Development Facilitation Team (DFT) – Review Comments

DRB Project No: PR-2020-003484 Date: 2/12/2025 Agenda Item: #3 Zone Atlas Page: E-10

Request: Replat of Lots 2 and 3 – create 19 lots from the existing tracts.

Application For: SD-2024-00158 – EXTENSION OF PRELIMINARY PLAT (DHO)

**MOJAVE SUBDIVISION**  
 GRADING AND DRAINAGE  
 GRADING PLAN

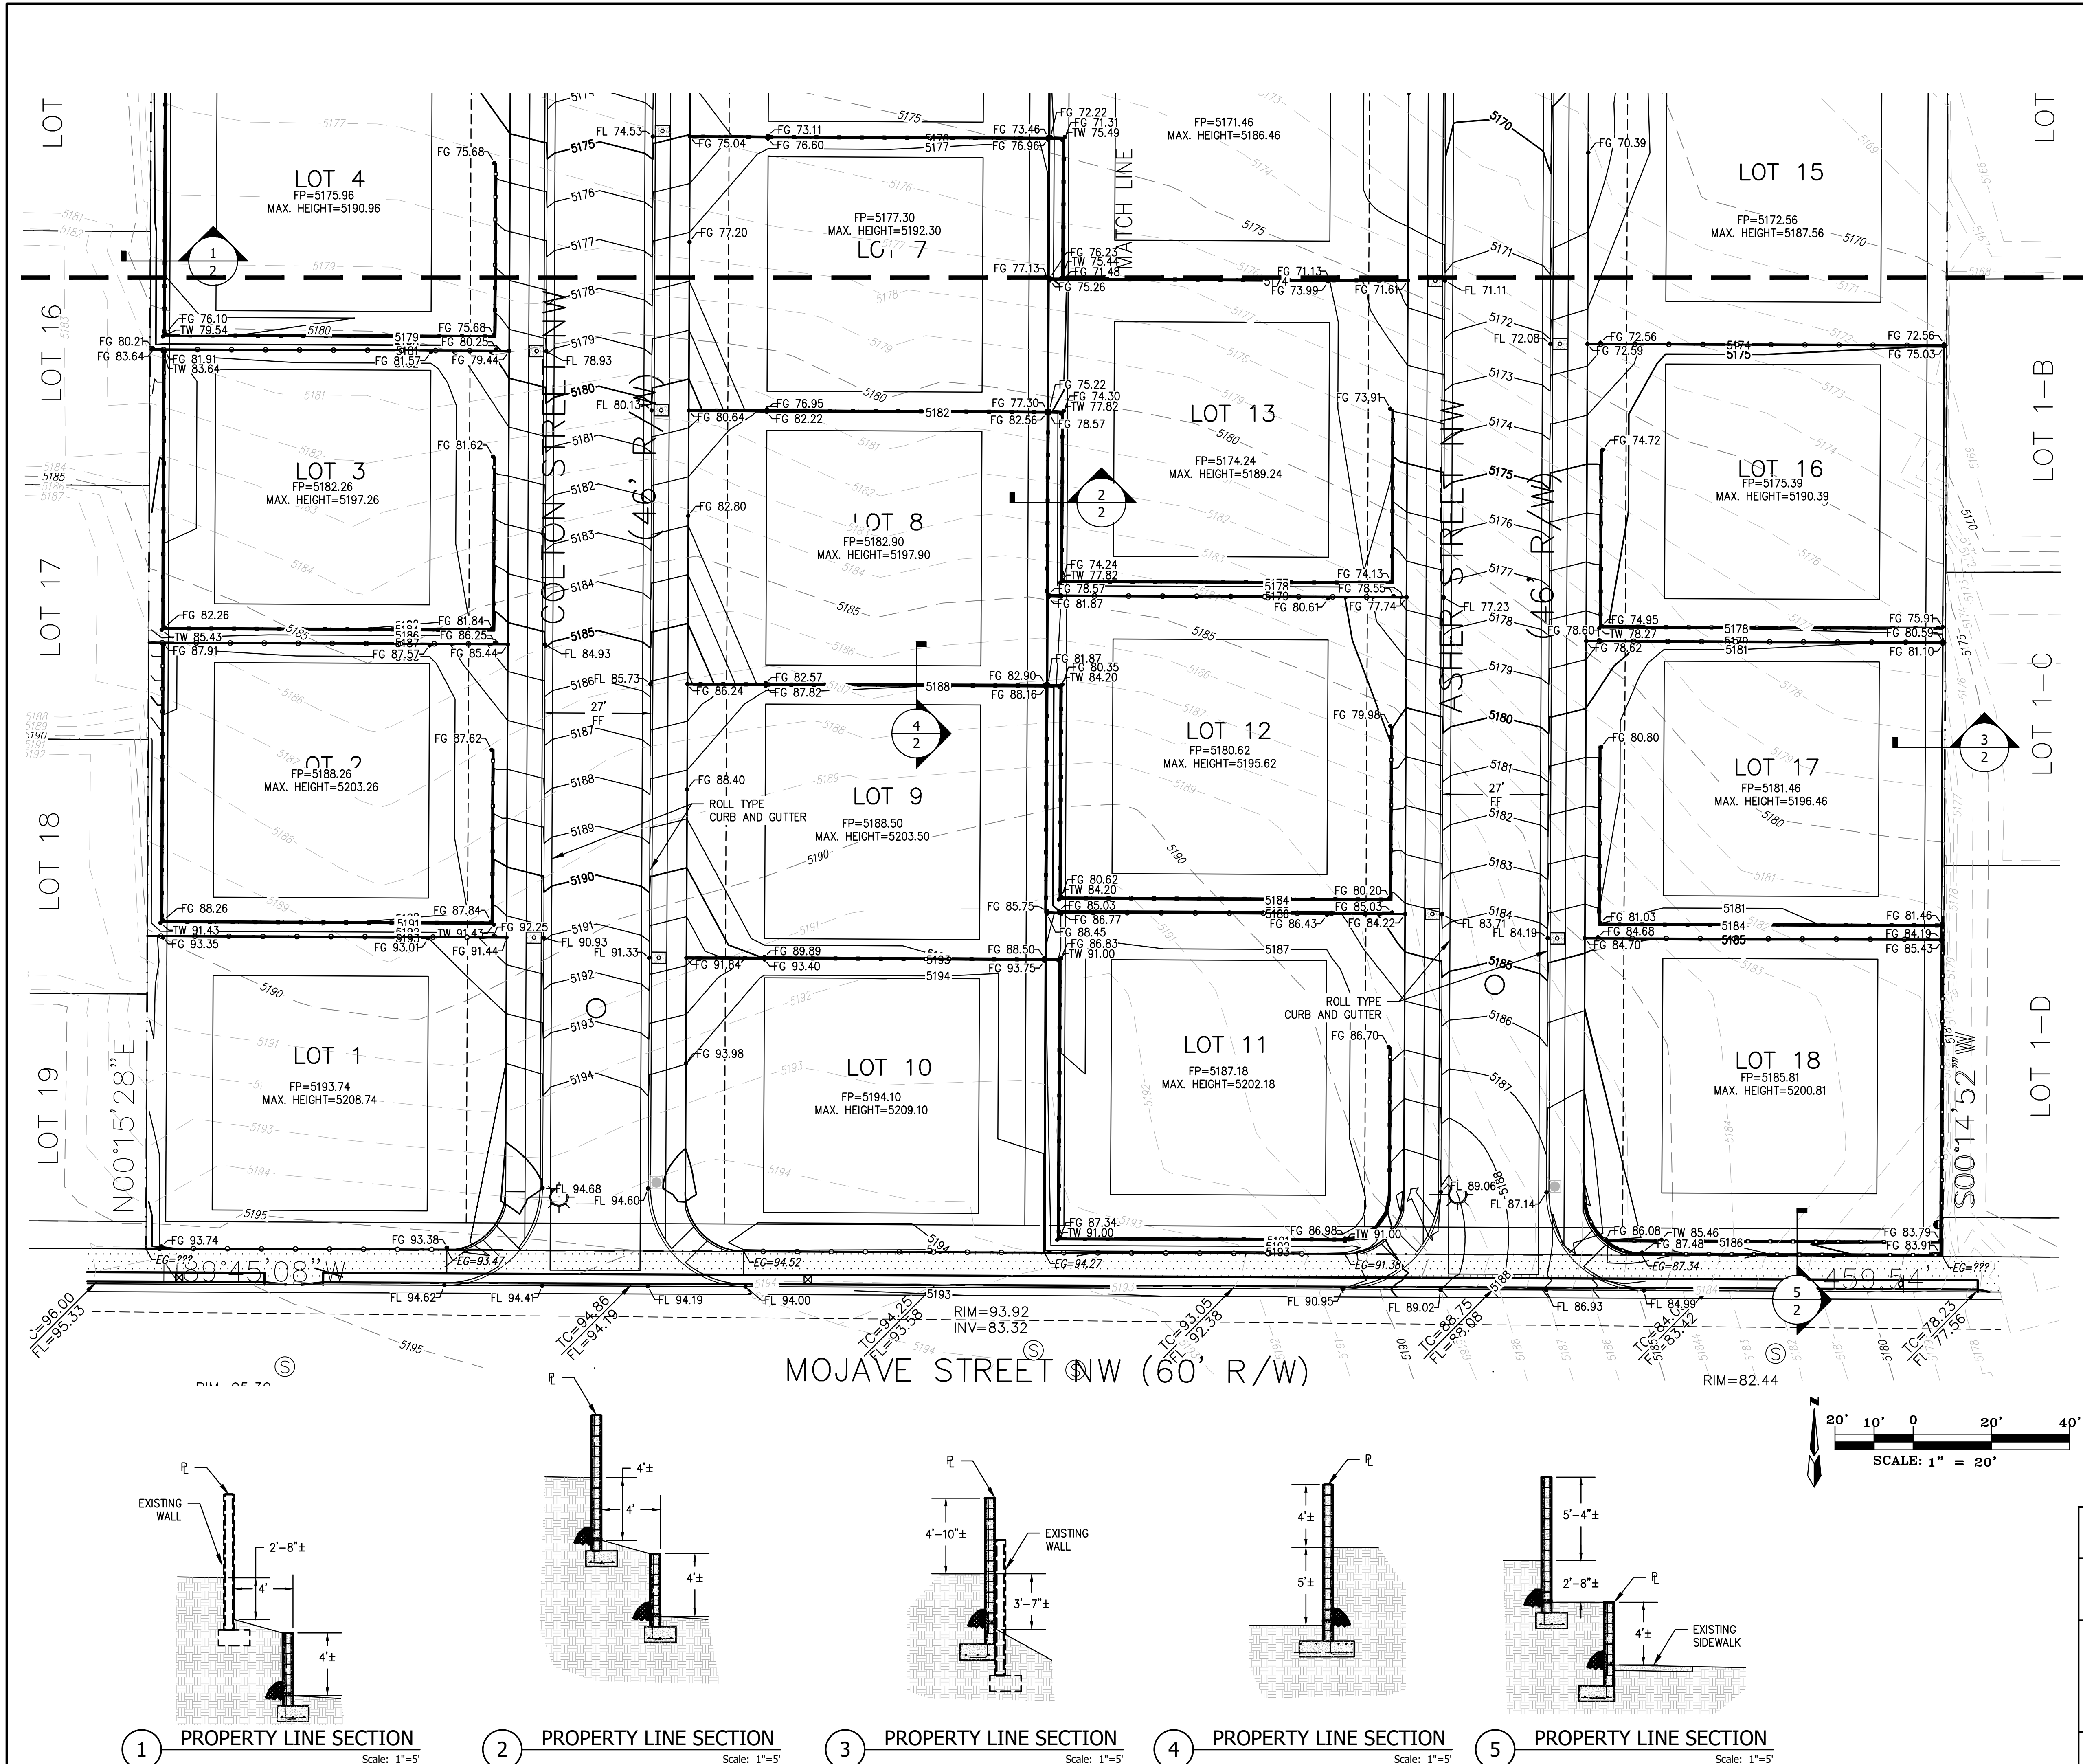
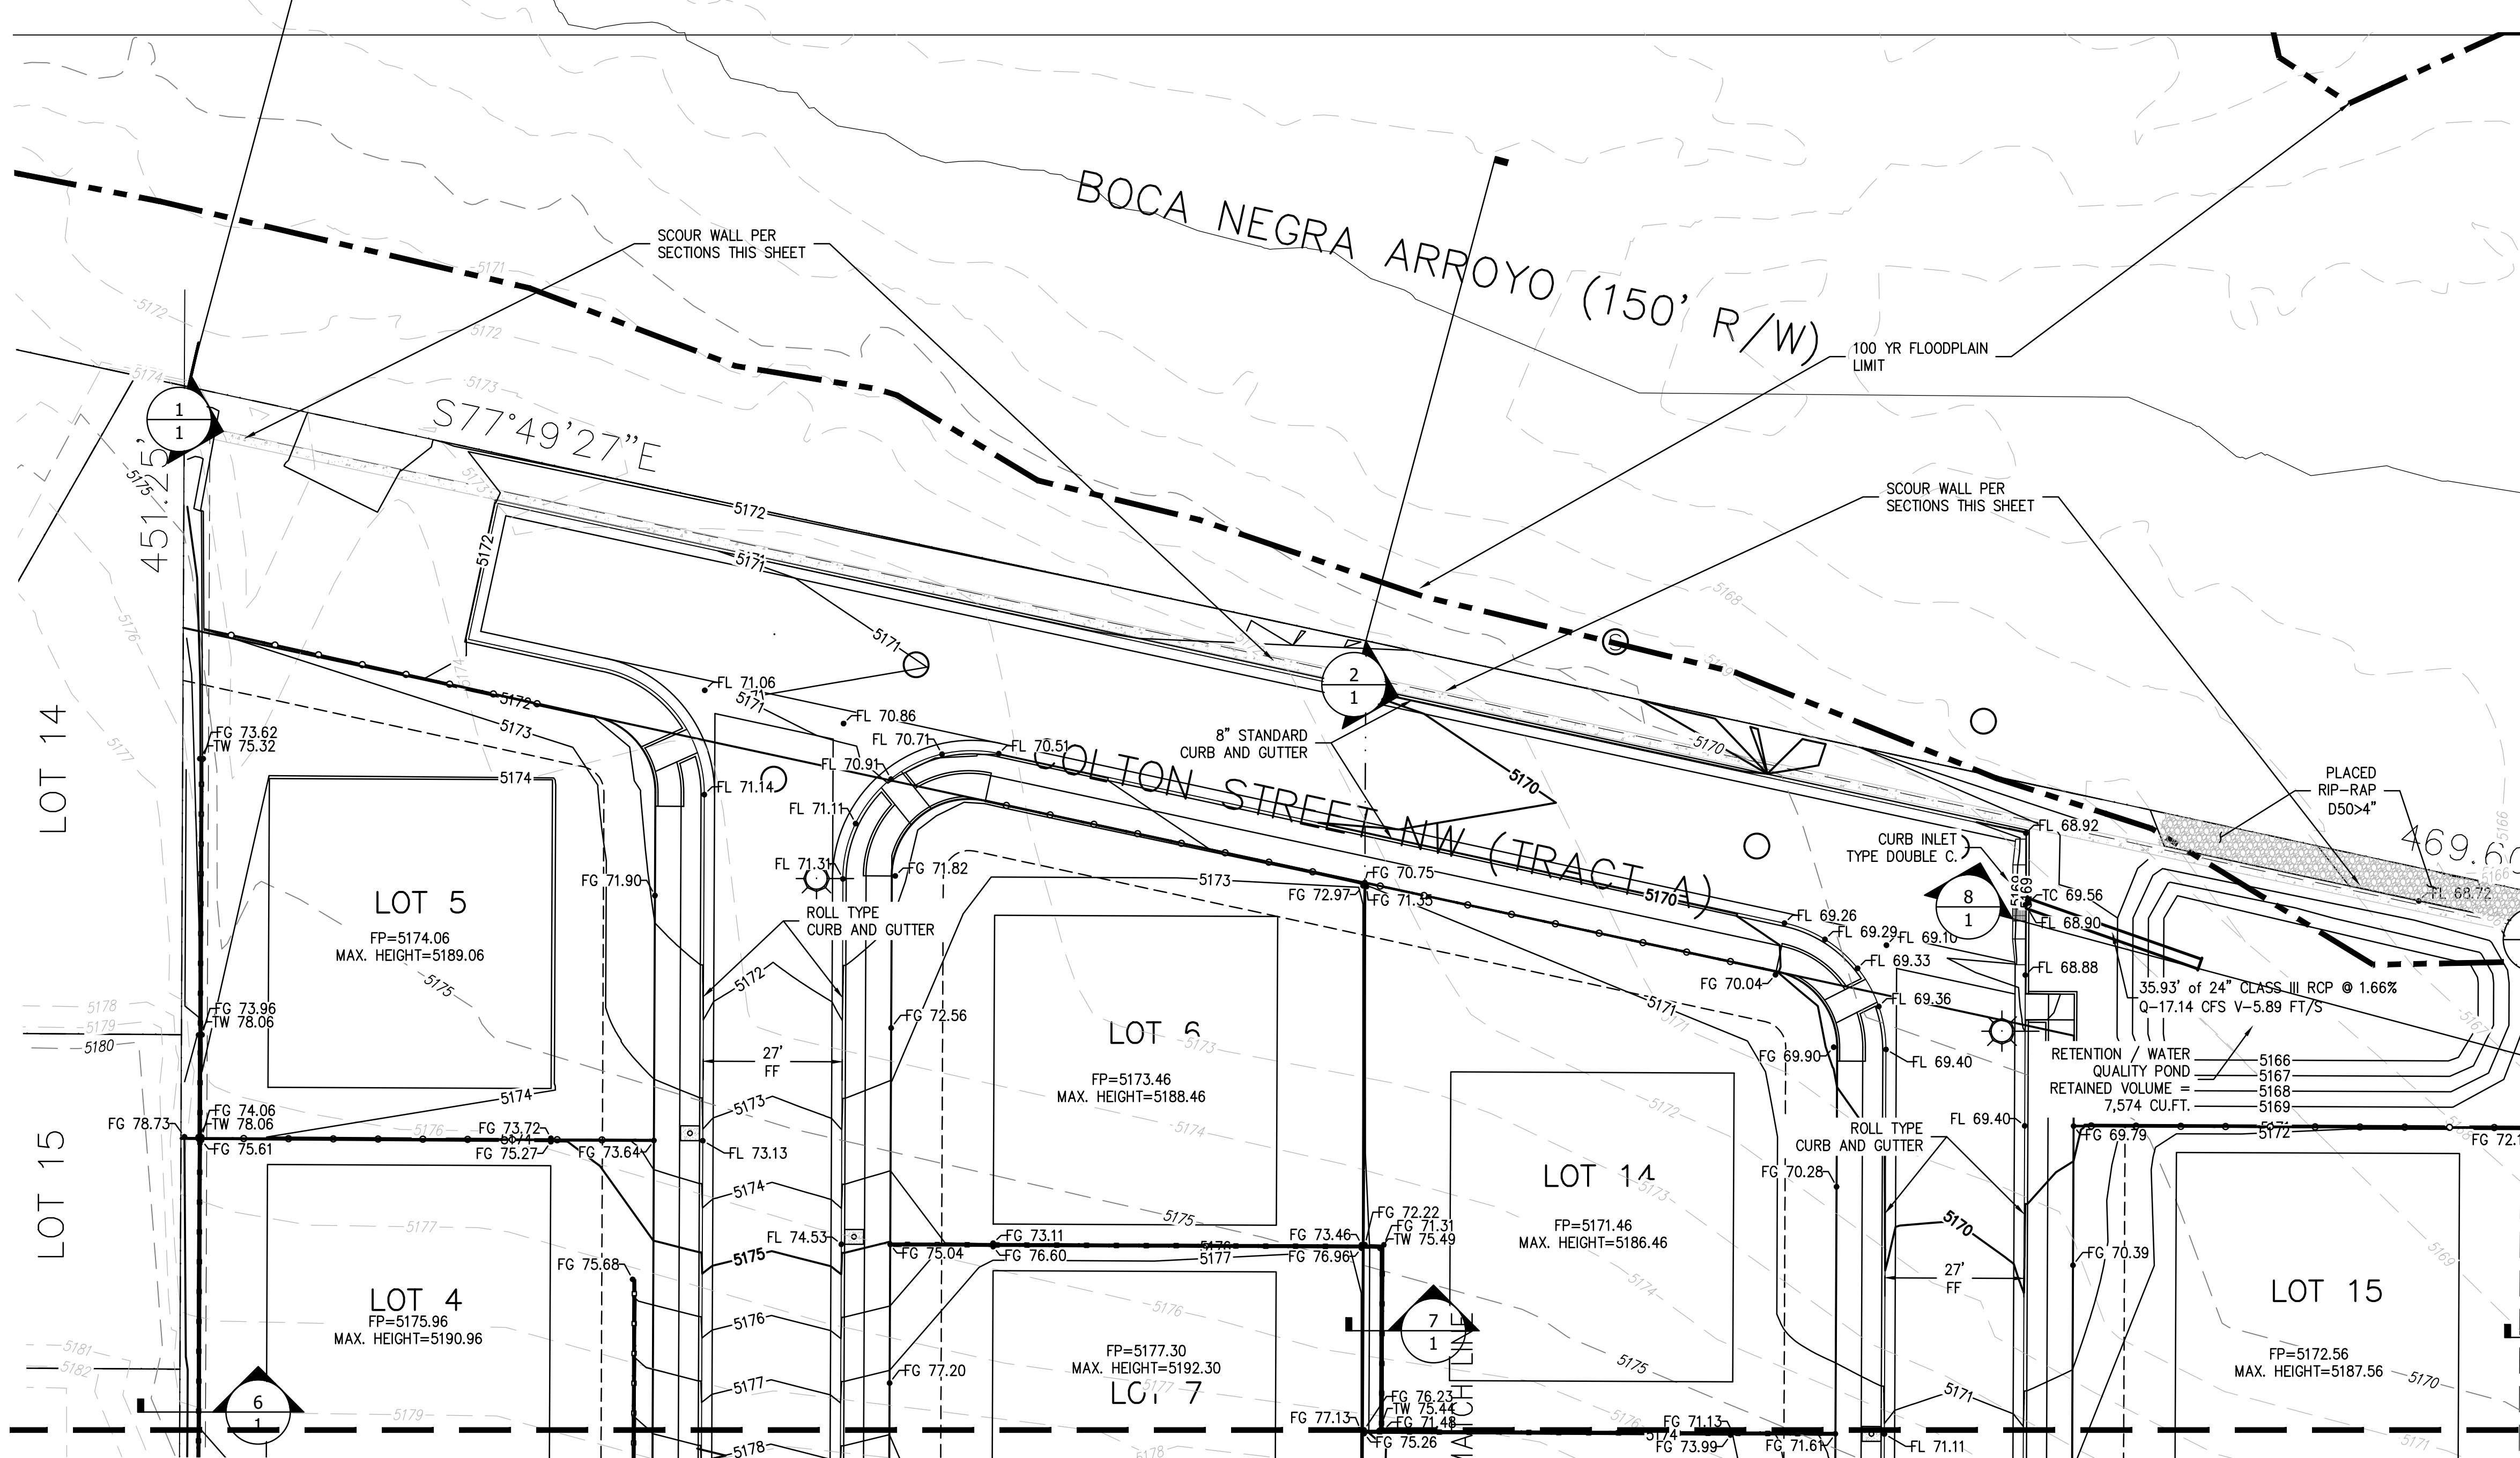
We support the construction of the scour wall as a continuous wall running the width of the development on the private property. It is not clearly defined on the Preservation Plan sheet if the scour wall would follow the entire northern boundary and request clarification and additional details on the Plan sheet.

We question the need for a turnaround area (or parking space) on the northwest portion of the property adjacent to the landscape buffer to the west.

We suggest that to protect the Monument north of the property, that a continuous layer of 4"-10" basalt rock be placed between the sediment pond and the property boundary, preserving the shrubs that currently exist in the area (without grading or additional soil disturbance). The rocks and vegetation would slow runoff to the maximum extent, reducing erosion and discouraging foot traffic in the area.

- In regards to adding rock to the border of the “non-disturbed” area along NR-PO-B MPOS to lessen the chance of erosion into MPOS/NPS; the Open Space Division agrees to the addition of 6-10-inch basalt rock to keep developed flows off of MPOS and the Monument. The OSD recommends larger rock rather than smaller gravel aggregate. The color should match the basalt that resides in the Boca Negra area to blend into the surrounding MPOS/NPS lands. All other “non-disturbed” land shall be left natural.

- Is there a requirement for the street to be built west and dead end? If there is not a requirement, we recommend this area not be developed. It could be an extension of the sensitive lands natural area on the northwest of the property.
